# PLANNING AMENDMENT

Application No. A09/0668/02

Steel Framed  
Building

**Re: PROPOSED STEEL FRAMED BUILDING**

DRAWING No. E6380/D1 REV A

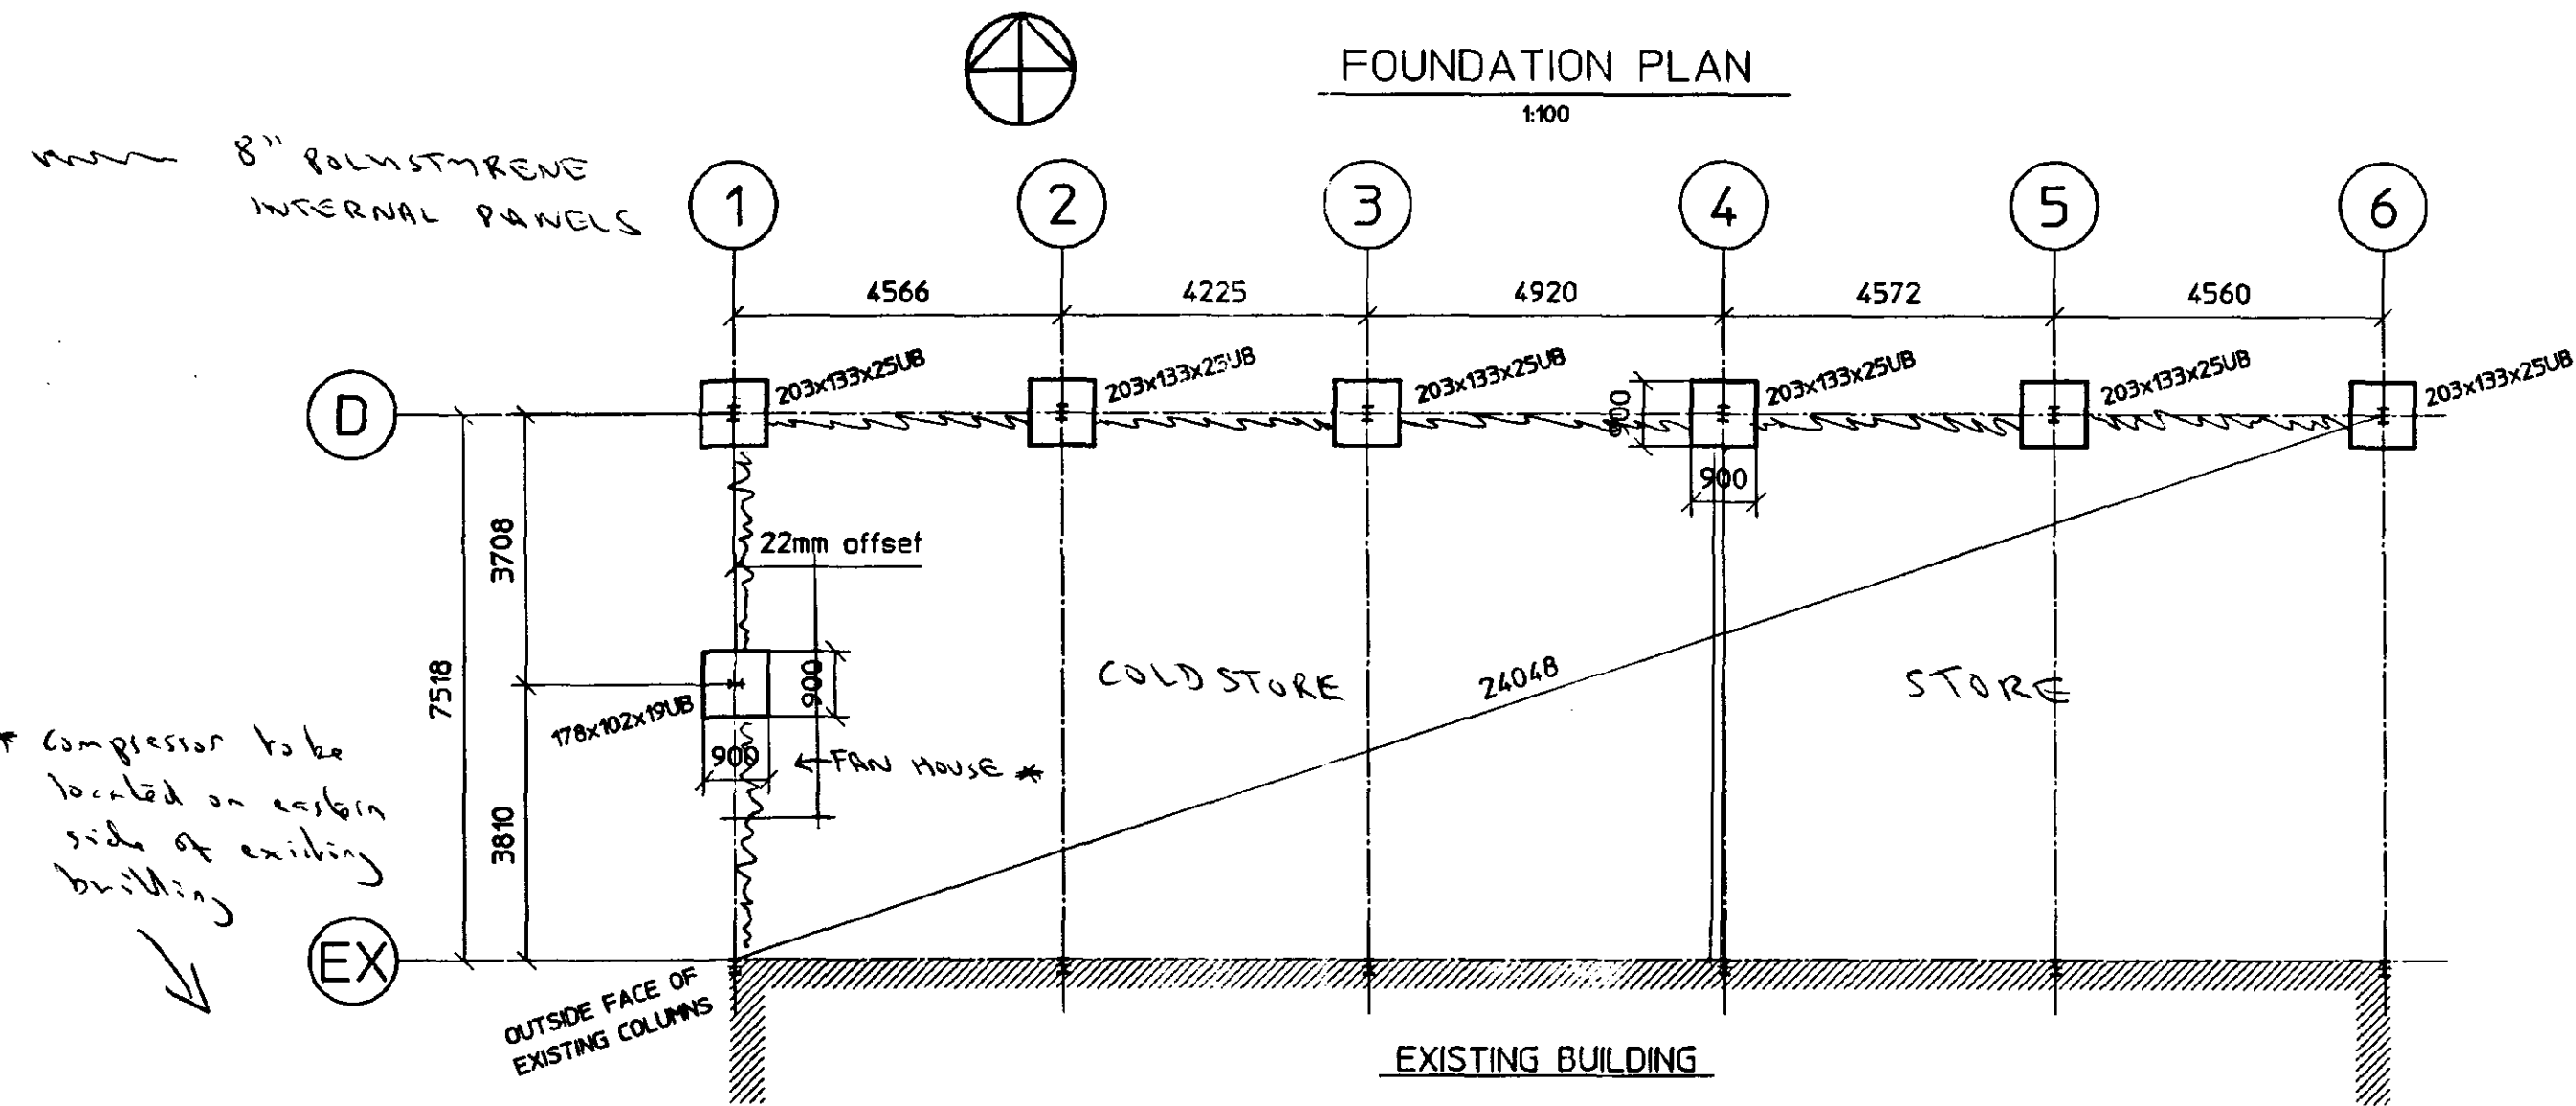
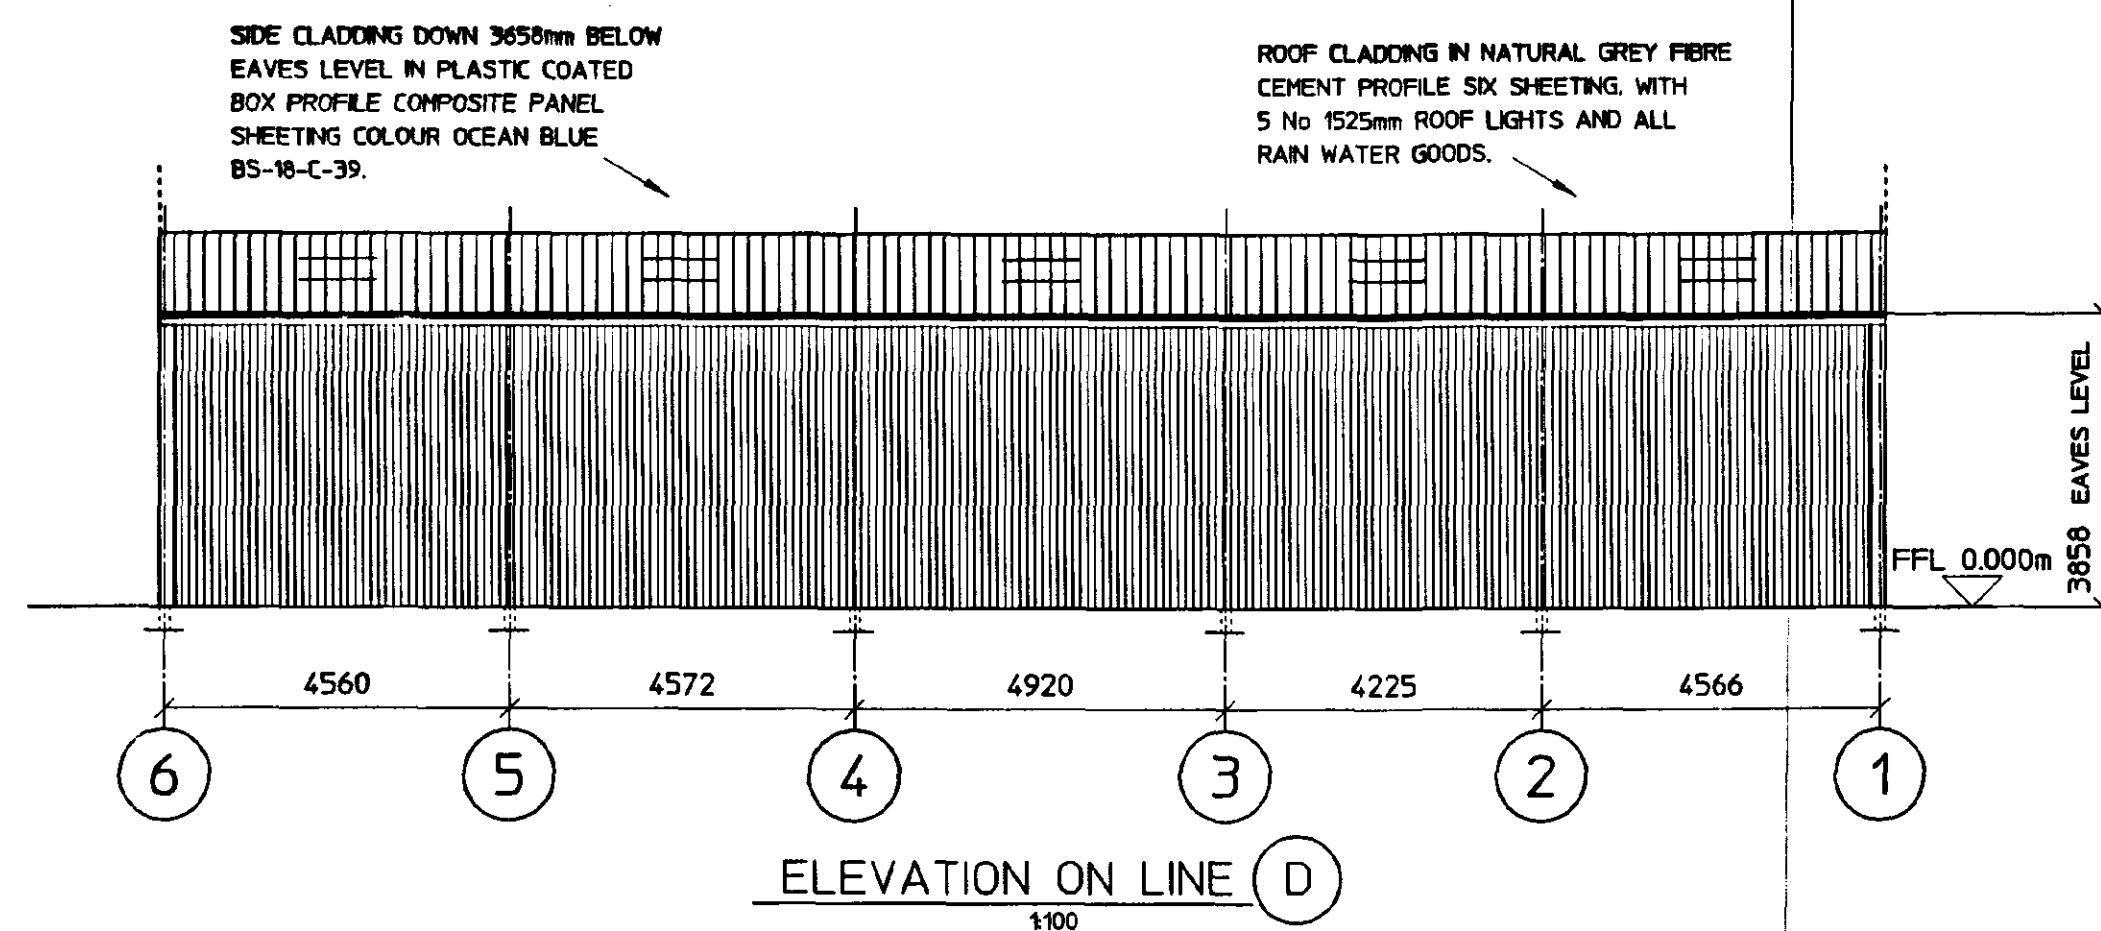
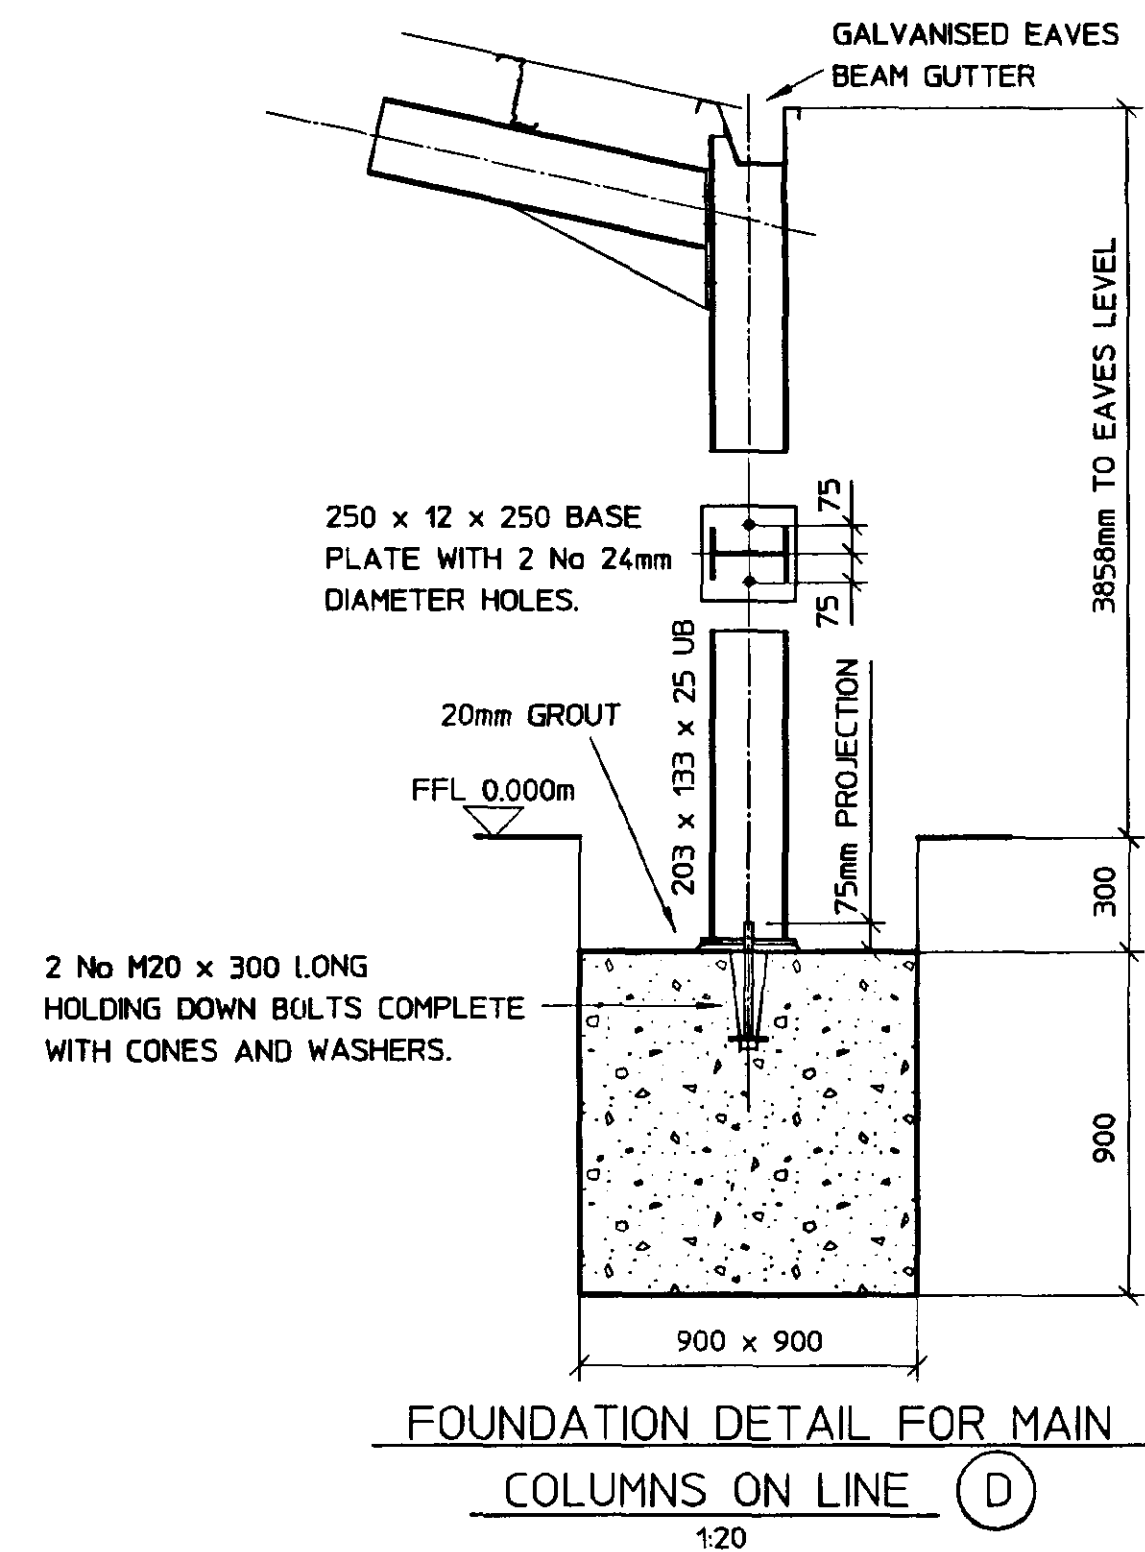
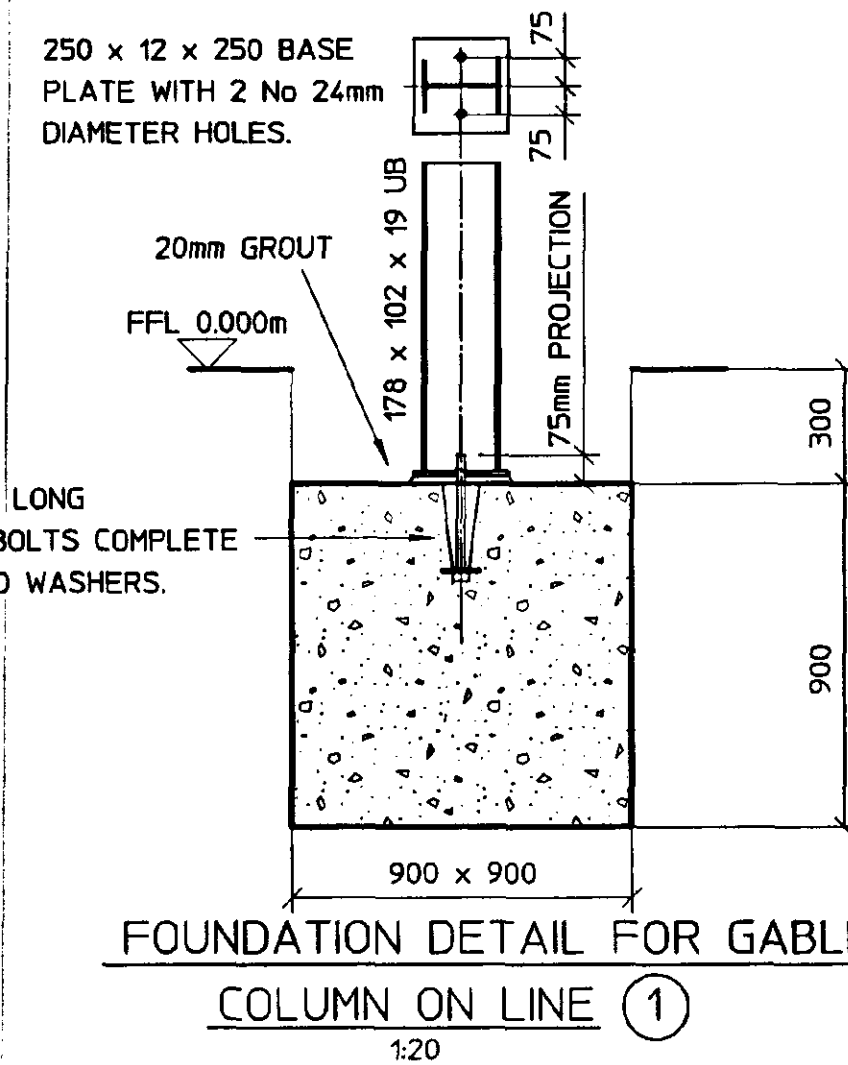
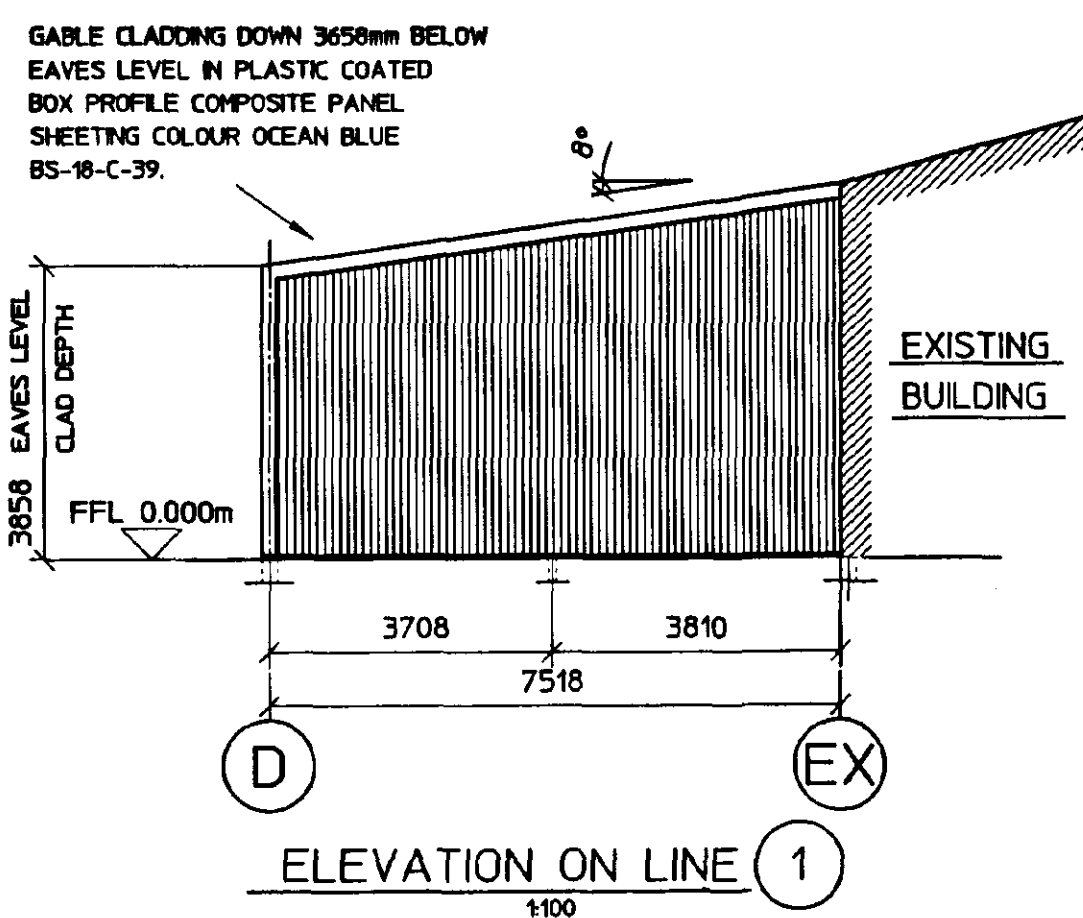
Composite  
Sheeting to  
north + west  
elevations

4No COPIES OF REVISED DRAWING E6380/D1 REVA , REGARDING PROPOSED COPOSITE SHEETING TO NORTH AND WEST ELEVATIONS AS REQUESTED IN YOUR LETTER DATED 14 AUGUST 02.
